Our Ref: P/21/19/PL

**Town & Country Planning Act 1990 (as amended)
Town and Country Planning (Development Management Procedure) (England) Order 2015
Application for Full Planning Permission**

Development New dwelling
Location 24 Lion Road Pagham

BLOCK PLAN (1:500)

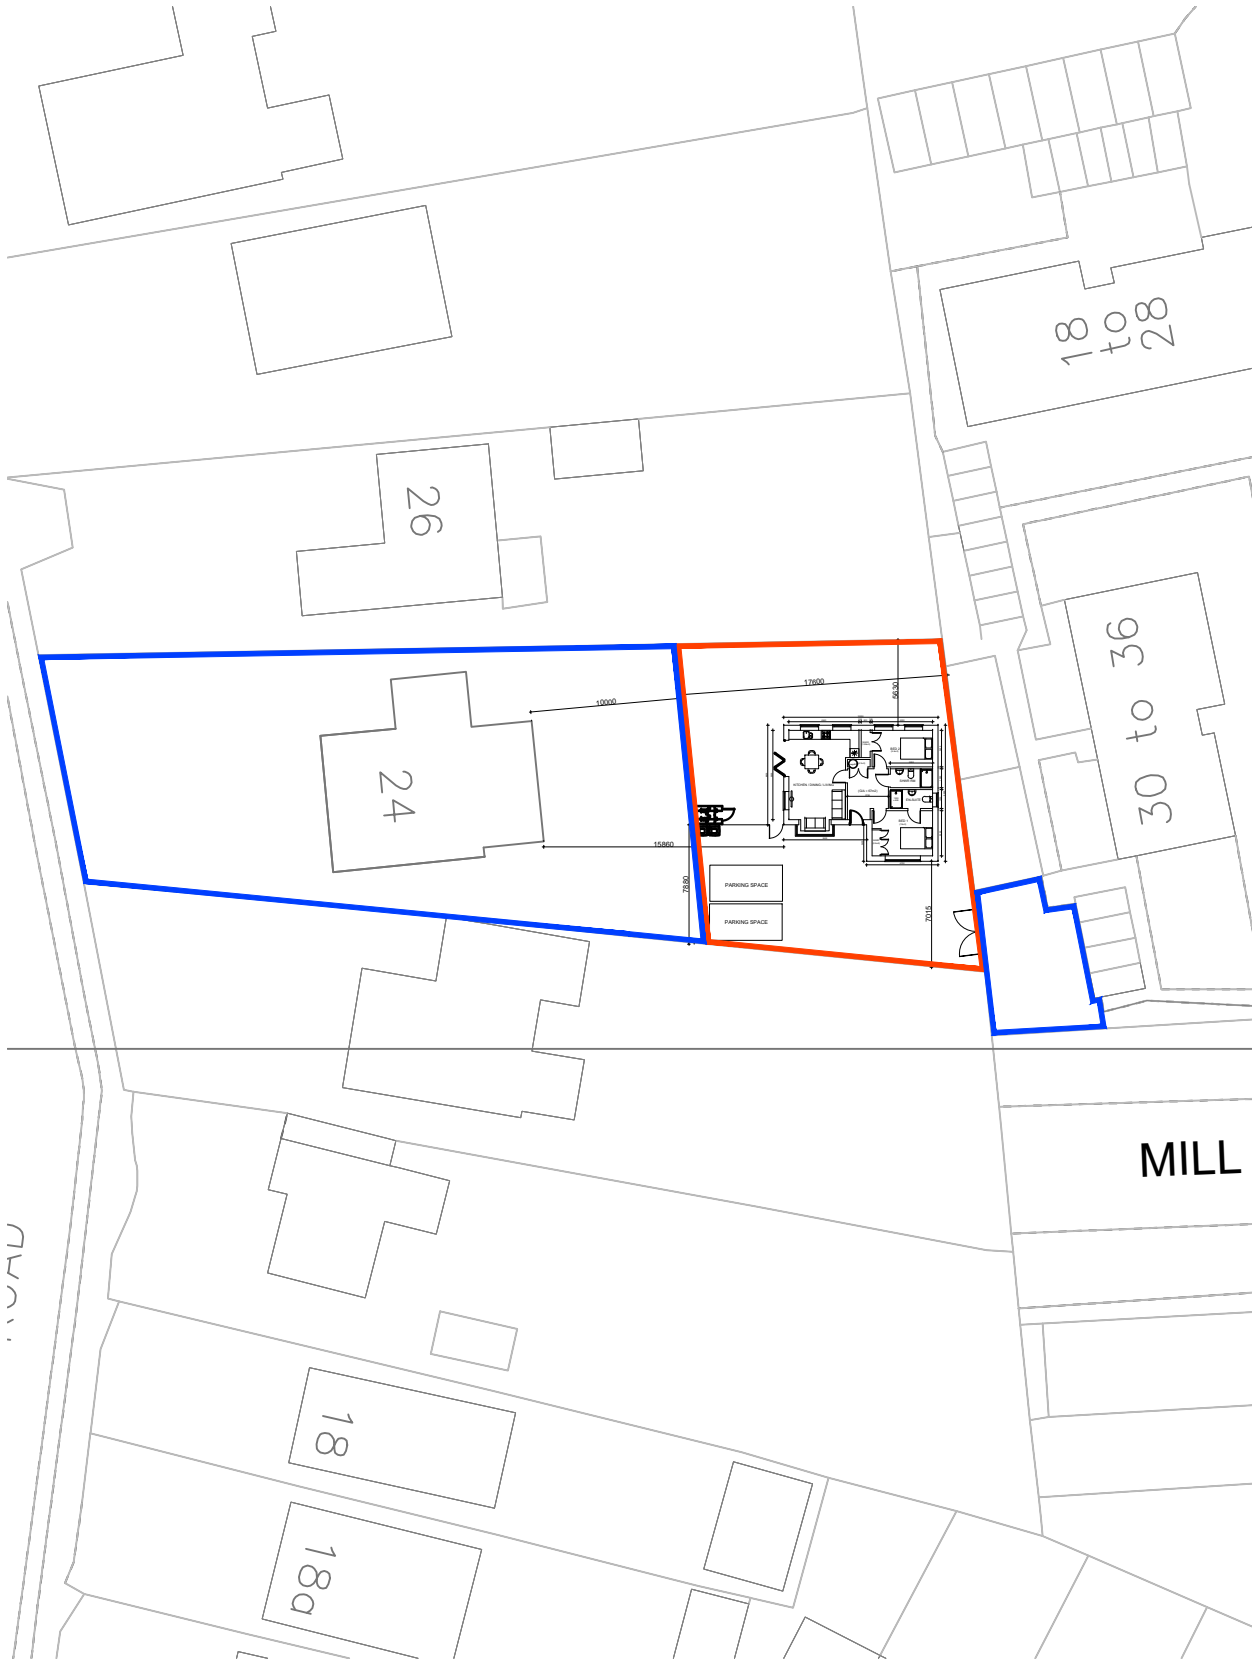
Block Plan

Please submit 1 electronic or 3 paper copies of a block/site plan at a scale of 1:500 or 1:200 to show the access points and visibility splays. Further details of what must be included on the plan can be found in the National Validation Requirements.

-	-	-
REV.	DATE	DESCRIPTION
CLIENT: S. Smith Land rear of 24 Lion Rd, Bognor Regis, West Sussex, PO21 3LA.		
Architectural Services t : 01428 879450 / 01243 767440 w: architectural.uk.com		
DRAWING: Location Plan		
1:1250 0 10 20 30 40 50		
DRG NO. 08/114-004	DATE: 14/12/18	SCALE: A3: 1:1250

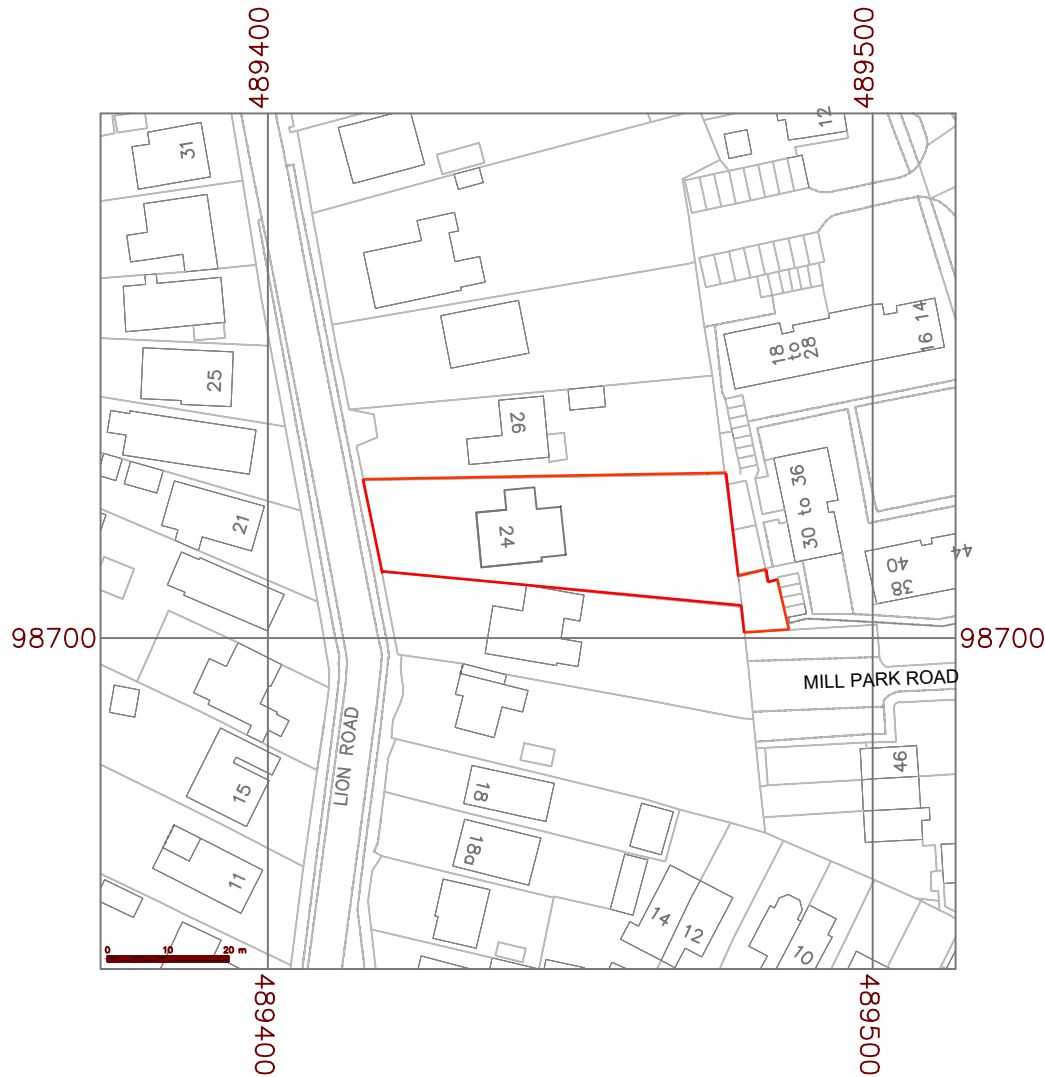
Location Plan

Please submit 1 electronic or 3 paper copies of an amended location plan at a scale of 1:1250 or 1:2500 for rural areas to show the access points and visibility splays. Further details of what must be included on the plan can be found in the National Validation Requirements.
